20/02446/F: Glebe Farm, Boddington Road, Claydon.

Claydon with Clattercote Parish Council I **object** to this proposal for the following reasons:

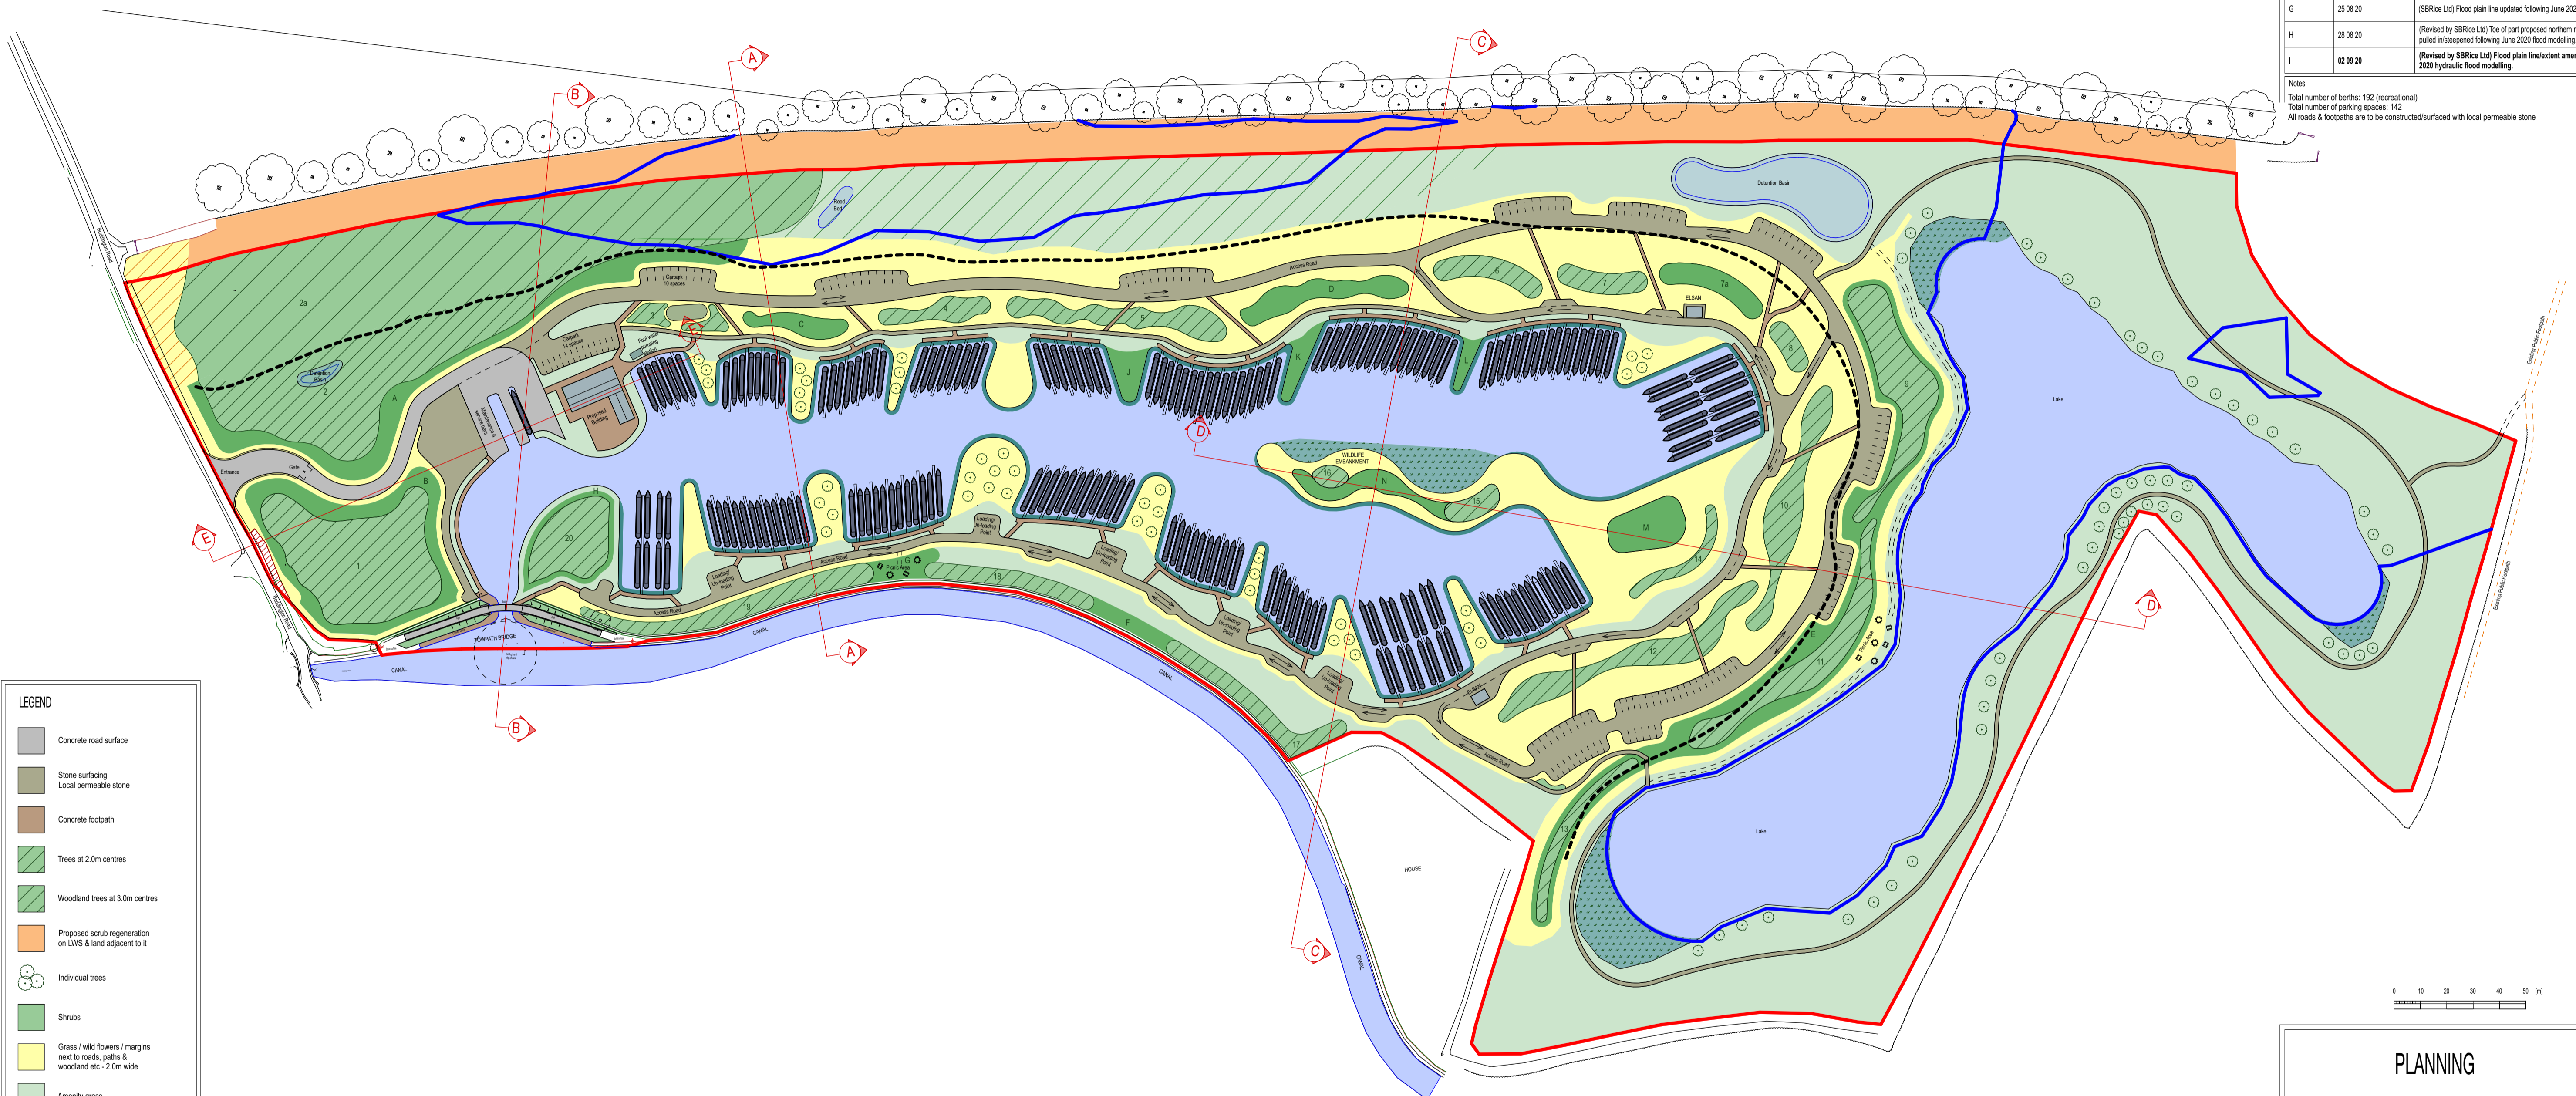
The reduction of the number of moorings is noted in the amended plans from the original but the scale of the proposed development is disproportionate for the area. The size of the pound and the moorings appears to be greater than the size of the whole of Claydon village. This is not appropriate, or in keeping with the quality of the environment of north Oxfordshire.

**Proposed Highways Access**  
Scale 1:200

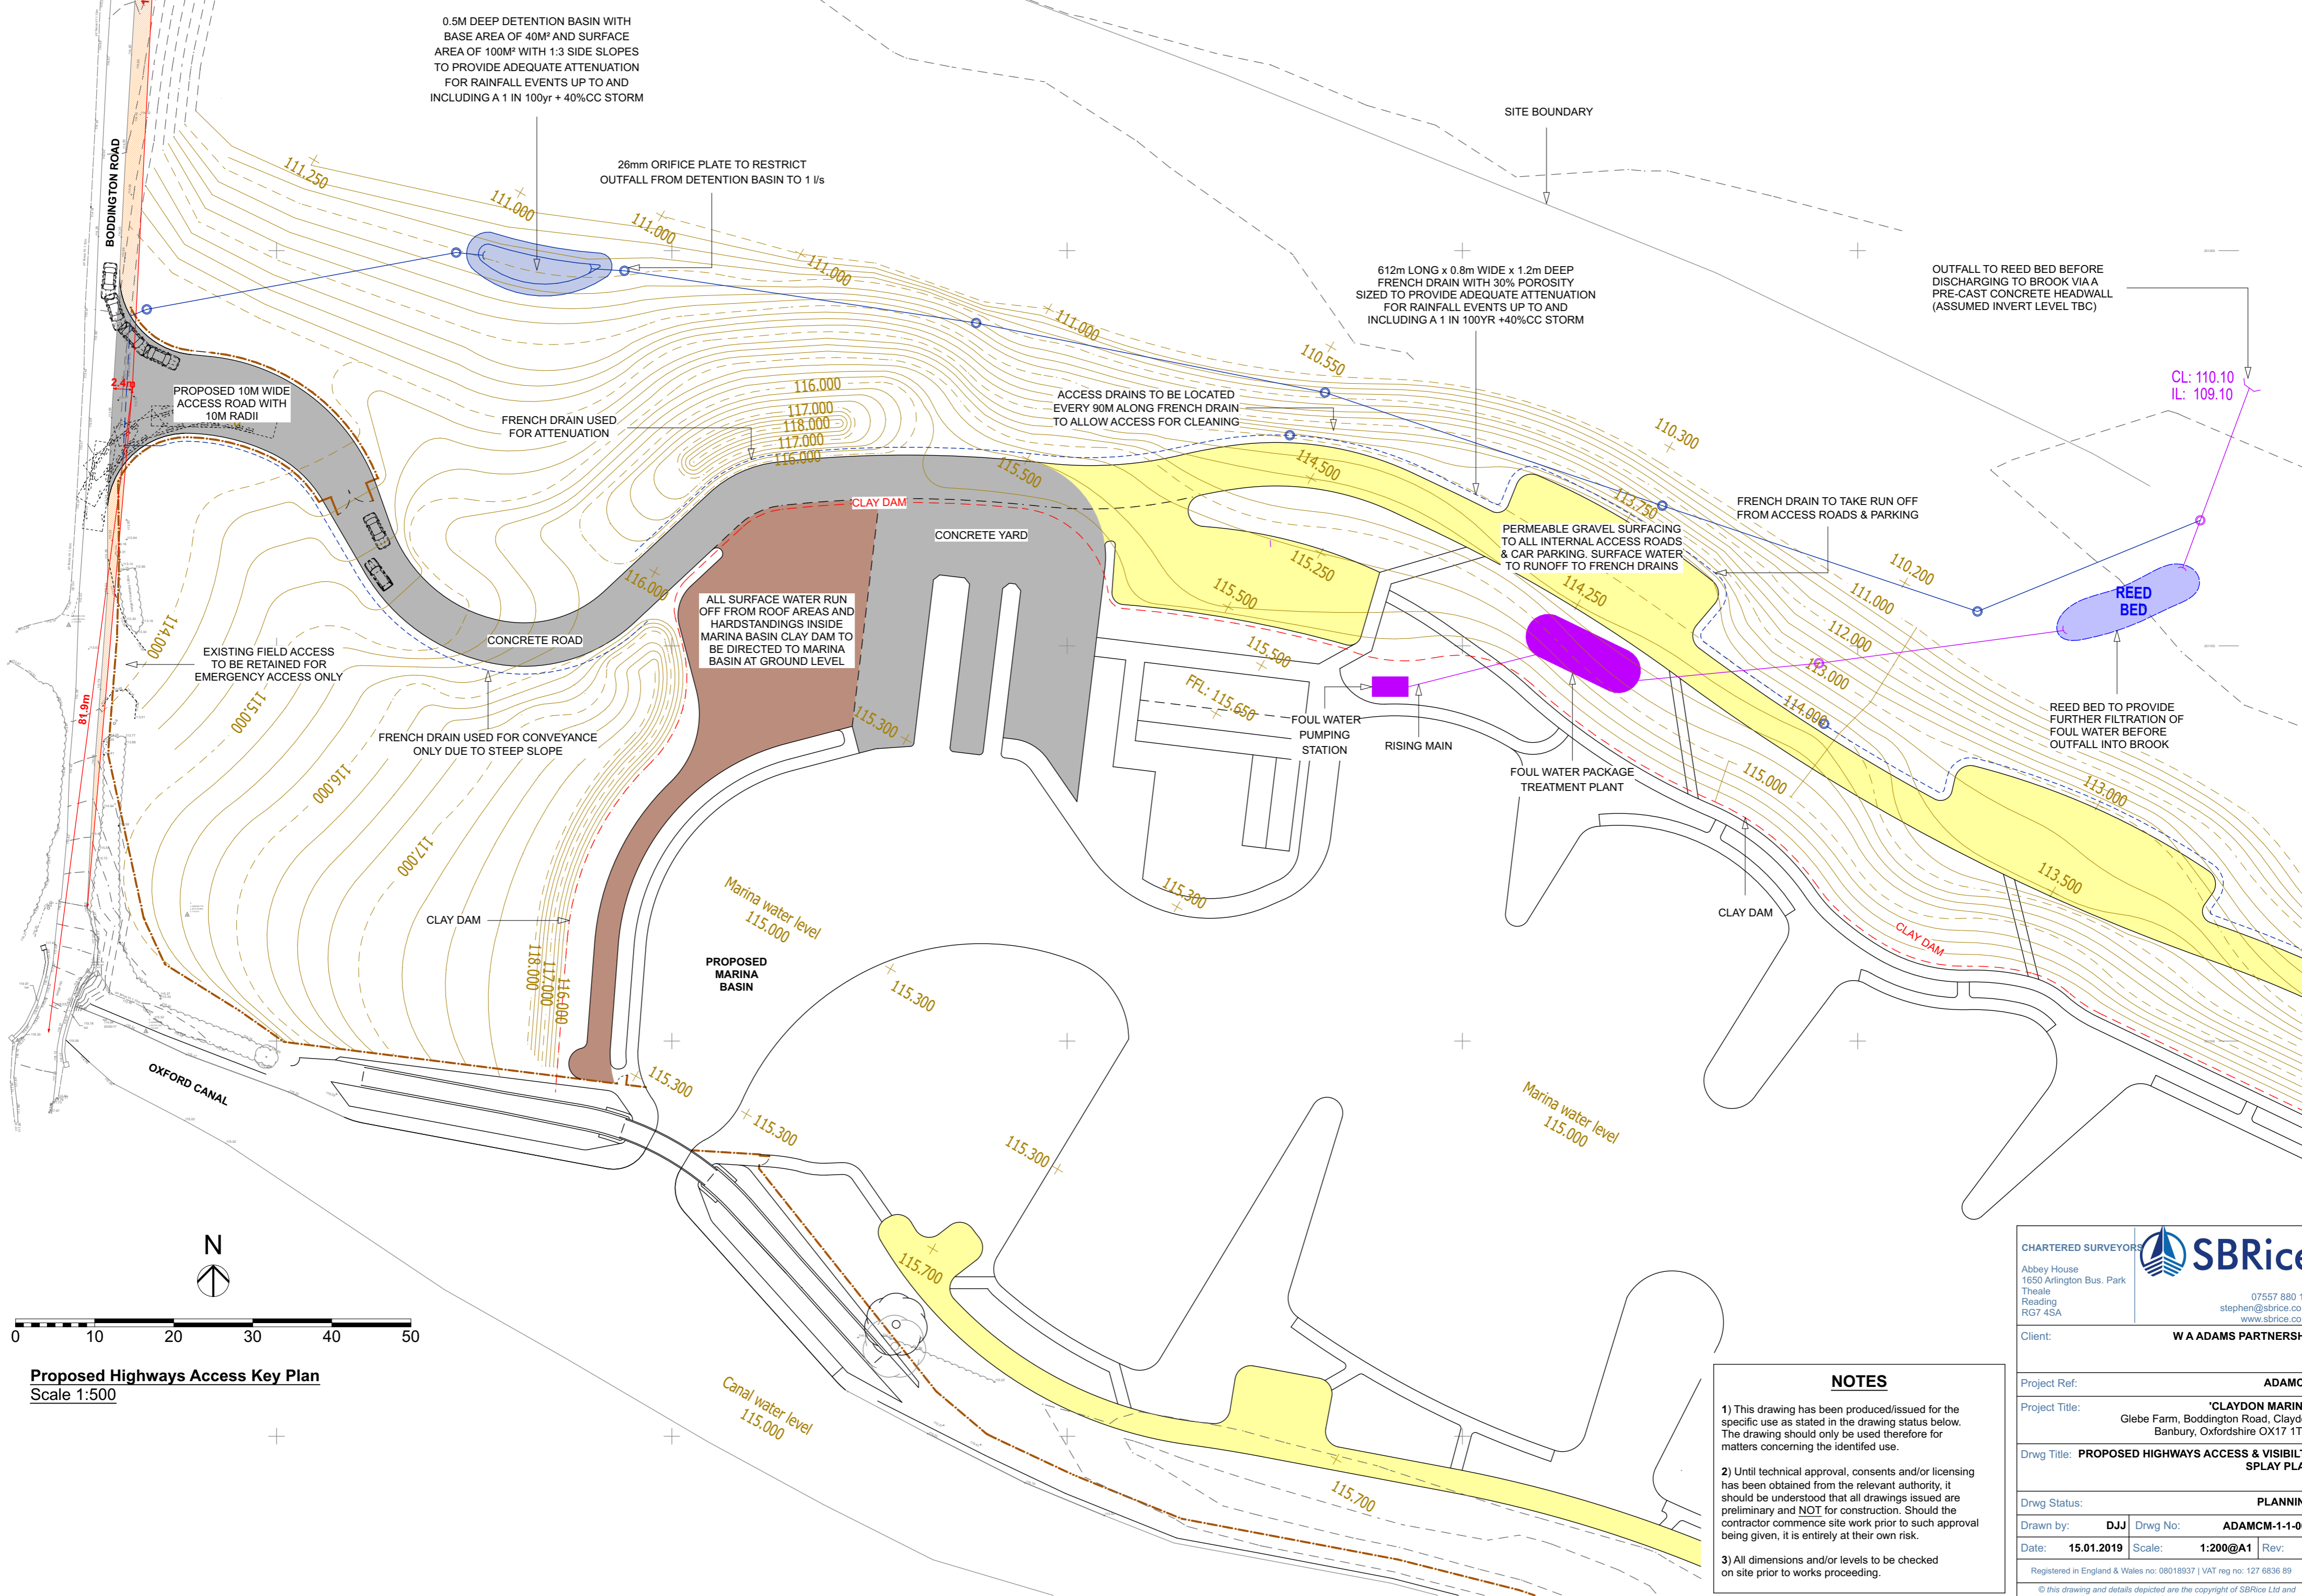
The 'proposed access arrangement with visibility splays' document states that the width of the track is 2.4m whereas in the Transport Statement (pg 6, paragraph 3.1) it states that the track is 3m wide. We have measured the width at various points of the track and believe it to be 2.75m wide.

The proposal shows a new entrance being created for the use of construction vehicles and marina users. We do not see why an additional entrance is required when the existing farm has an entrance which is suitable for use by vehicles (Please see photo below of existing entrance).
